**Consultation Response from KC,
Highways Development Management****2025/91905 Land at, Woodhead Road, Honley, Holmfirth, HD9 6PU****Erection of temporary veterinary surgery and associated works****Date Responded: 18/09/2025****Responding Officer: CNB****Responding Ref: K3-49/2**

DRAWING No: 2504303 REV: P03

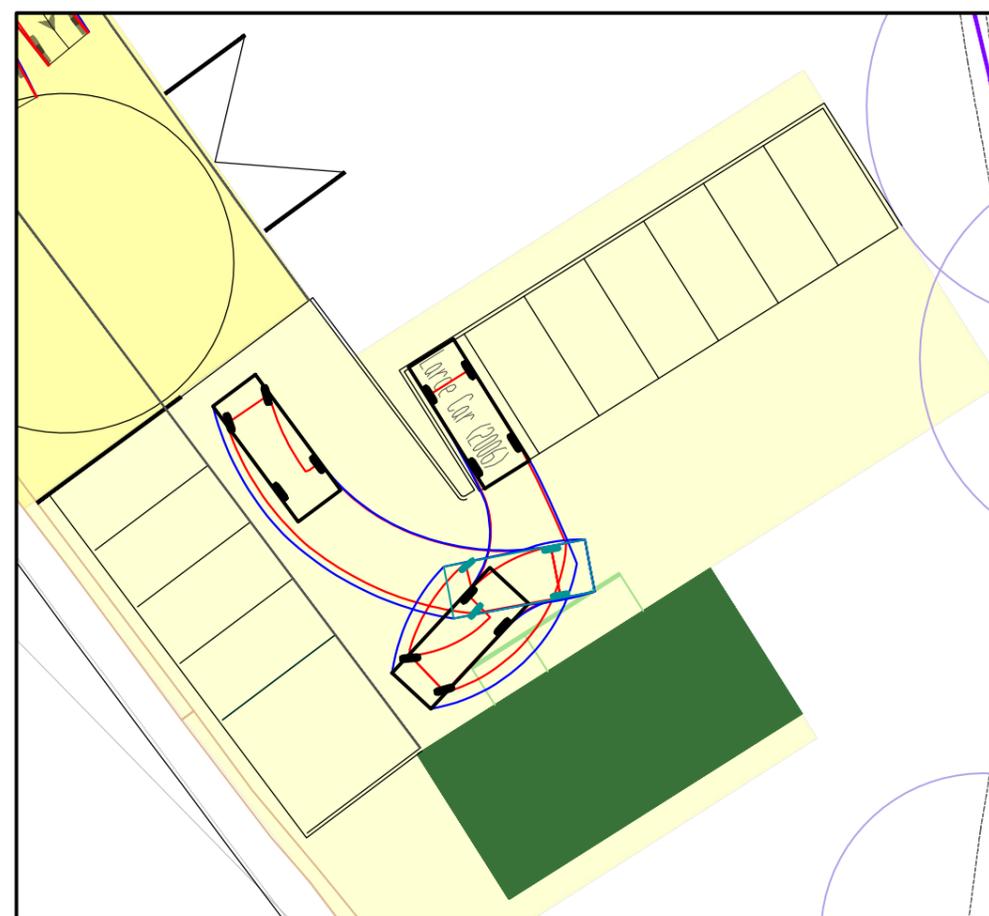
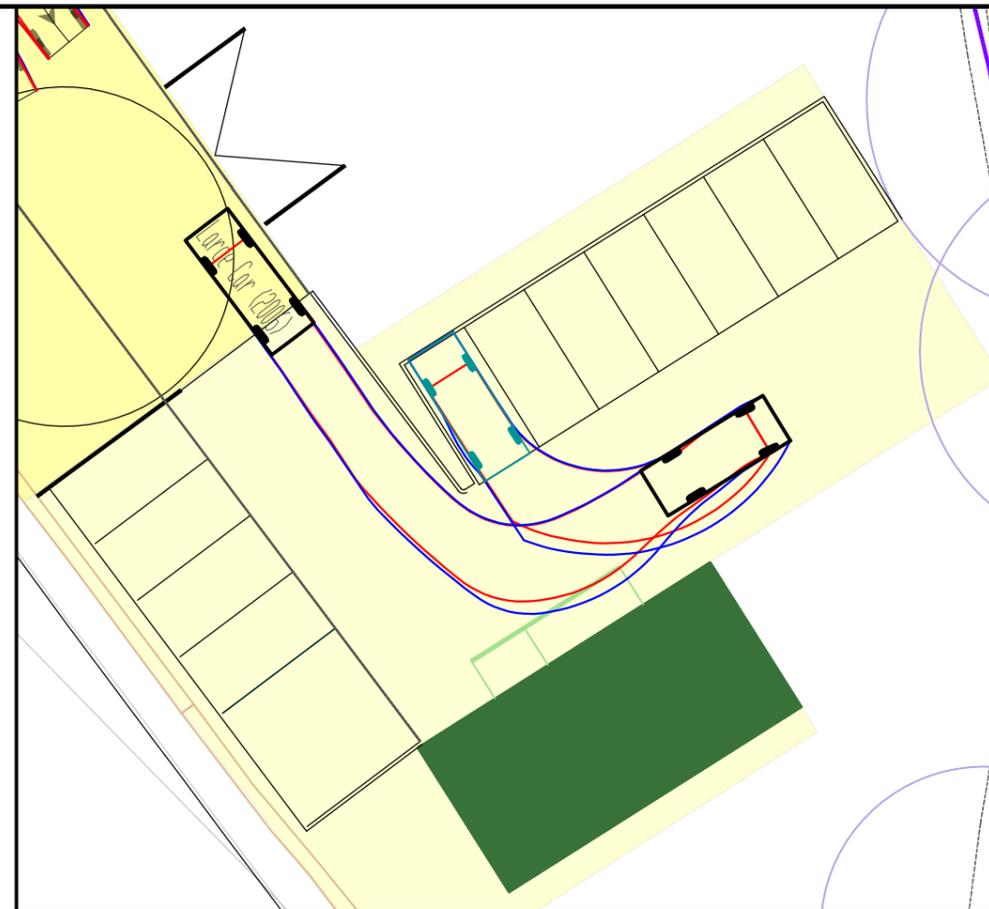
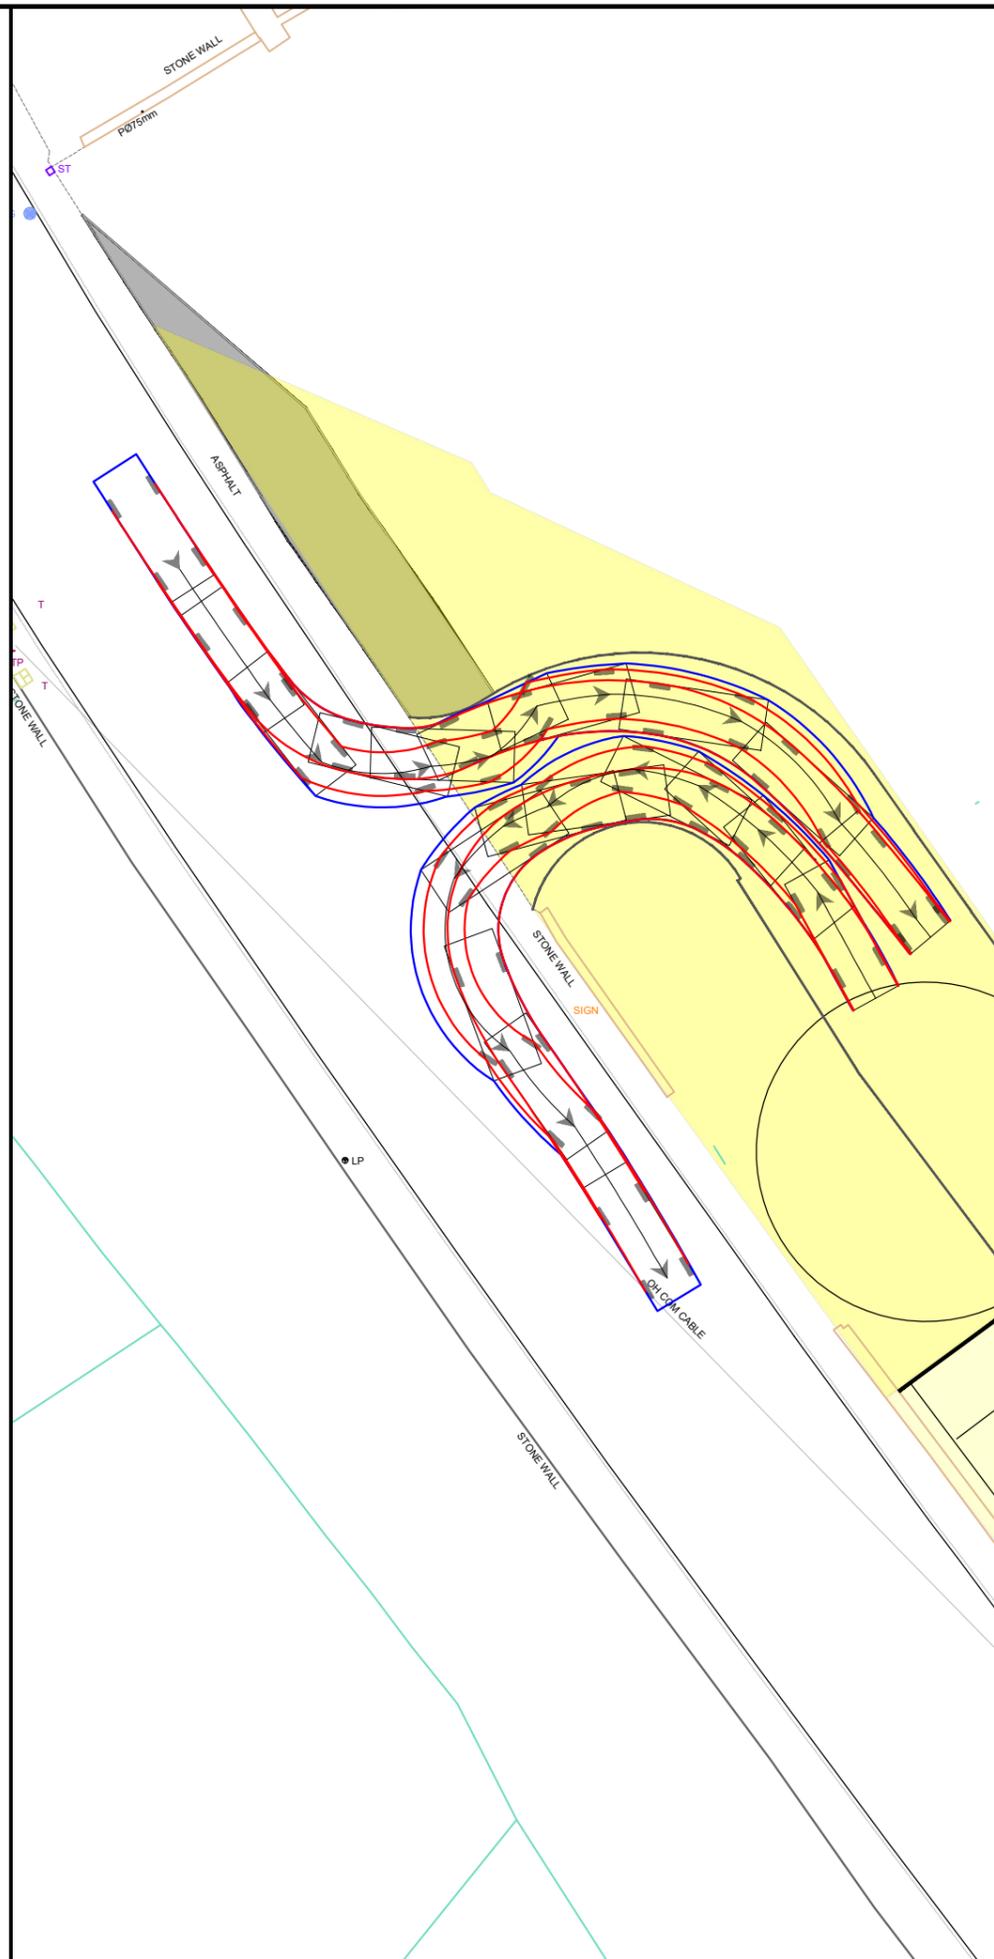
Drawing No 2504303 Rev P03 shows a swept path analysis indicating that a large car can safely enter and exit the site and can access the parking spaces and turn within the site to allow entry and exit in forward gear. Drawing No 2504302 Rev P03 shows a swept path analysis for waste collection at the site and indicates a 12m refuse wagon can safely access the site for waste collection. It is assumed that, when not in use for waste collection, the space indicated on drawing No 2504302 Rev P03 can also be used for large deliveries for the construction of the veterinary hospital.
